PRE-HEARING STAFF ANALYSIS

Rezoning Petition No. 2004 -136

Location: Approximately 3.741 acres located east of the intersection of Moores Chapel Road and Belmeade Drive

Request: R-3, LLW-PA, single family residential Lower Lake Wylie Protected Area to B-2 (CD), LLW-PA, general business conditional Lower Lake Wylie Protected Area

Illustrative Site Plan-Scheme A  
SCALE: 1:40

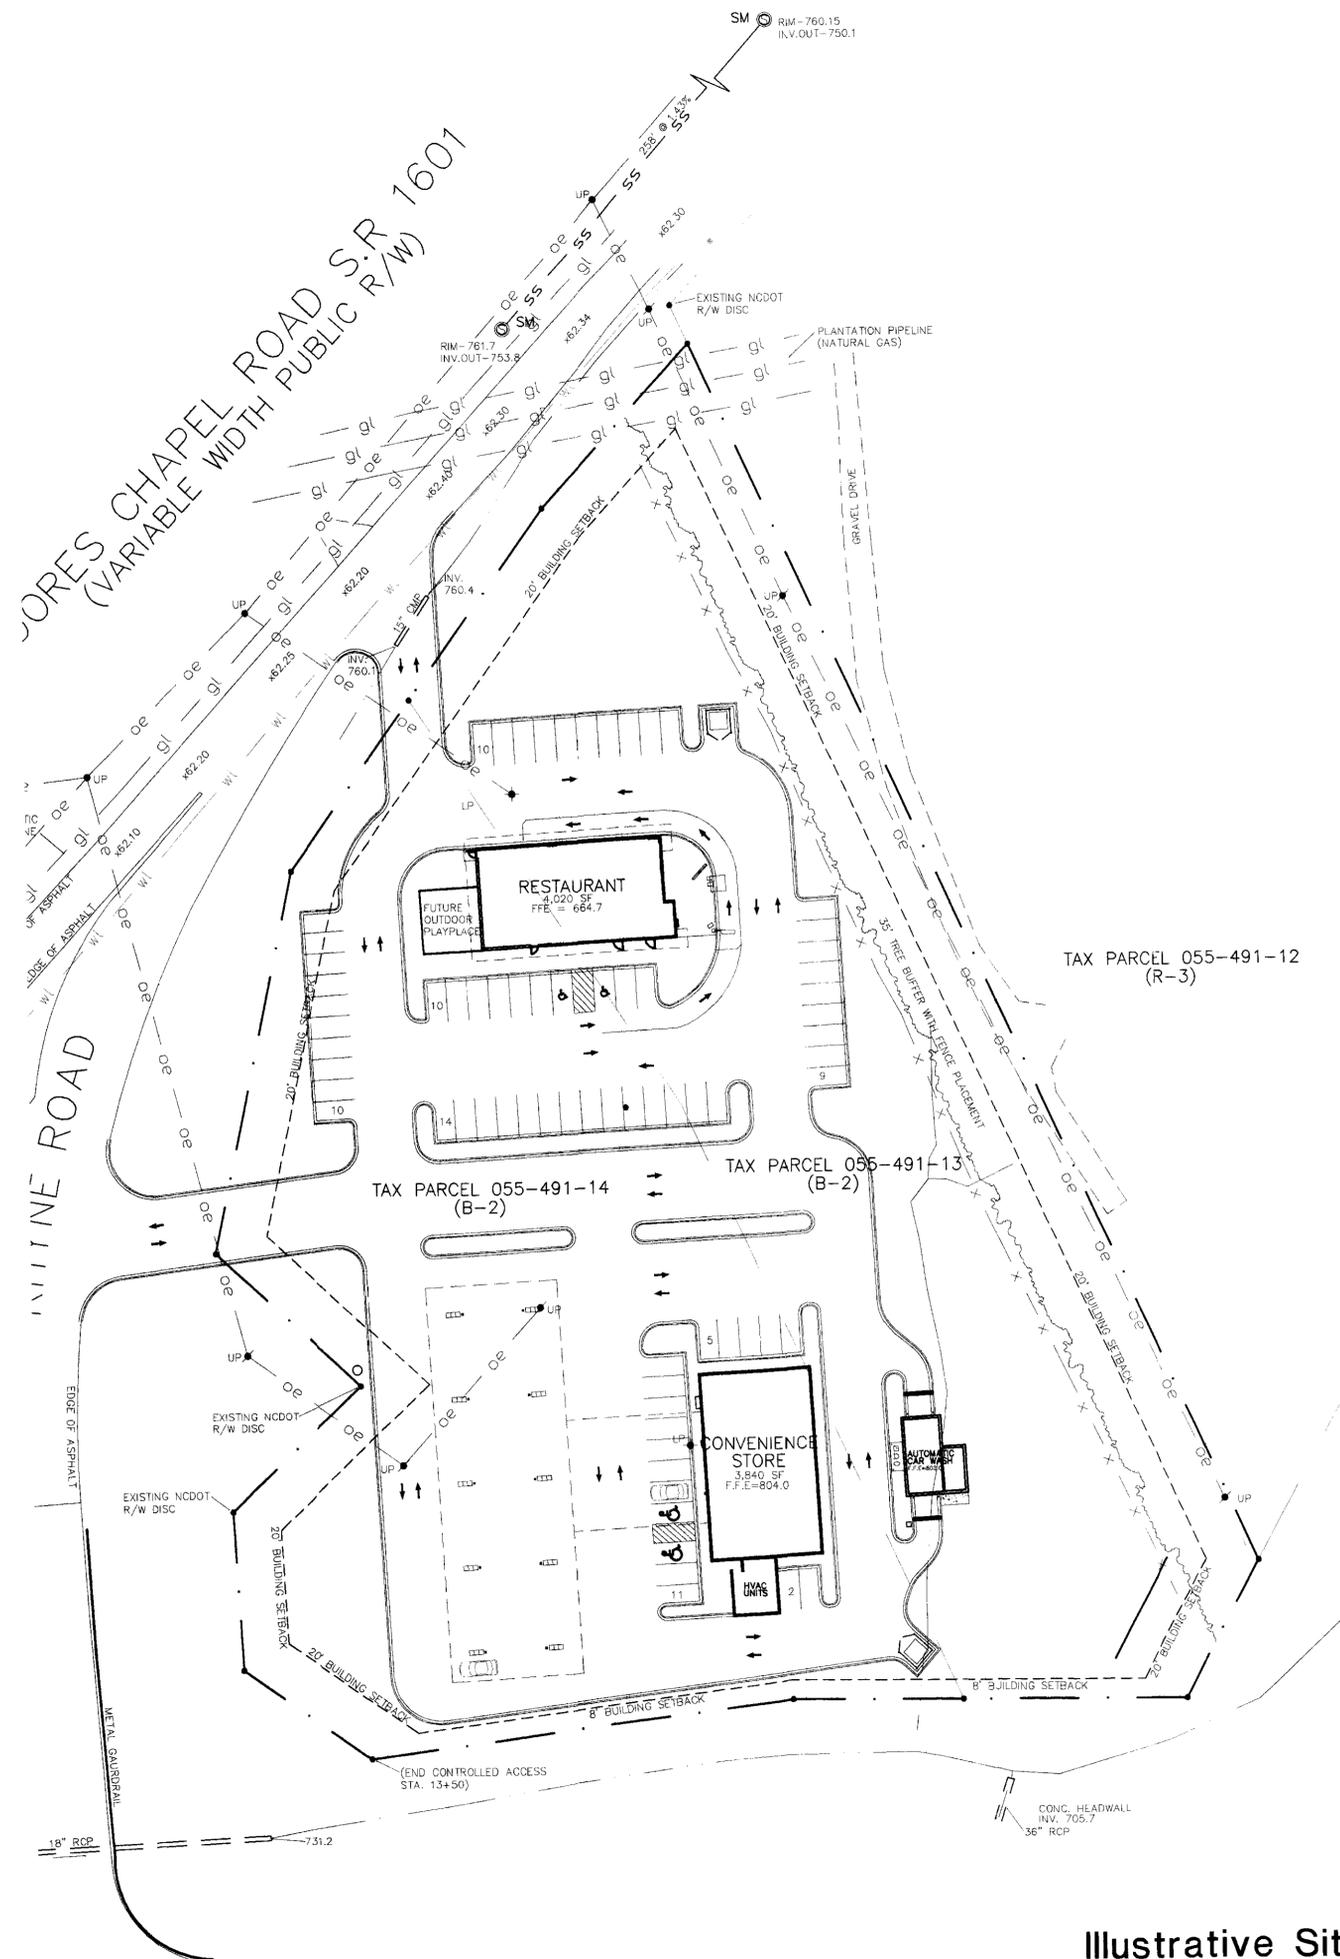
- The site plan should reflect the final configuration of Rhyne and Moores Chapel Roads at completion of the NCDOT project. Items such as pavement markings, edge-of-pavement and right-of-way lines on both sides of all roads shown should be clearly illustrated on the conditional plan.
- CDOT can only support one driveway to serve the proposed development. The driveway must be a Type III- street type access and be located directly across from Belmeade Road. This driveway should extend through the site as a public street and stub to the adjacent property.

- According to the City of Charlotte's Driveway Regulations, CDOT has the authority to regulate/approve all private street/driveway and public street connections to the right-of-way of a street under the regulatory jurisdiction of the City of Charlotte. CDOT has determined that a left-turn lane is necessary to serve the traffic using the proposed public street/private driveway connection for this site. The engineering design and construction of the left-turn lane is the responsibility of the owner, and shall be performed by a professional engineer registered in the State of North Carolina who has roadway-design experience. CDOT will only approve the proposed public street/private driveway connection provided that a left-turn lane is constructed on Rhyne Road. We recommend the rezoning plan reflect the design of this required left-turn lane prior to submittal/approval of the public street/private driveway connection. This roadway improvement is required to meet the traffic demands of the proposed development. The left-turn lane should be designed with a minimum 150 feet of storage, a 15:1 bay taper and 45:1 through lane tapers.

- Sidewalk, curb, and gutter will be required along the public street frontage for this site. The rezoning exhibit should show the sidewalk, curb and gutter in the public right-of-way for Moores Chapel Road and Rhyne Road.

- The site plans shows the parcel fronting a street with two names, Moores Chapel Road and Rhyne Road. Since the completion of the realignment of Moores Chapel Road in this area, the road is now named Rhyne Road and should be labeled as such on the rezoning exhibit.

Connectivity. The site plan shows potential connectivity to the adjacent property in anticipation of it being rezoned to a non-commercial classification.

- The petitioner shall tie-in to the existing storm water system(s). The petitioner shall have the receiving drainage system(s) analyzed to ensure that it will not be taken out of standard due to the development. If it is found that development will cause the storm drainage system(s) to be taken out of standard, the petitioner shall provide alternate methods to prevent this from occurring.

Land Use. The rezoning request is fairly consistent with the Westside Strategic Plan land use recommendations. However, water quality concerns must be addressed and the site should provide greater vehicular and pedestrian connectivity to the contiguous property located to the northeast along Moores Chapel Road that is also recommended for retail/commercial land uses.
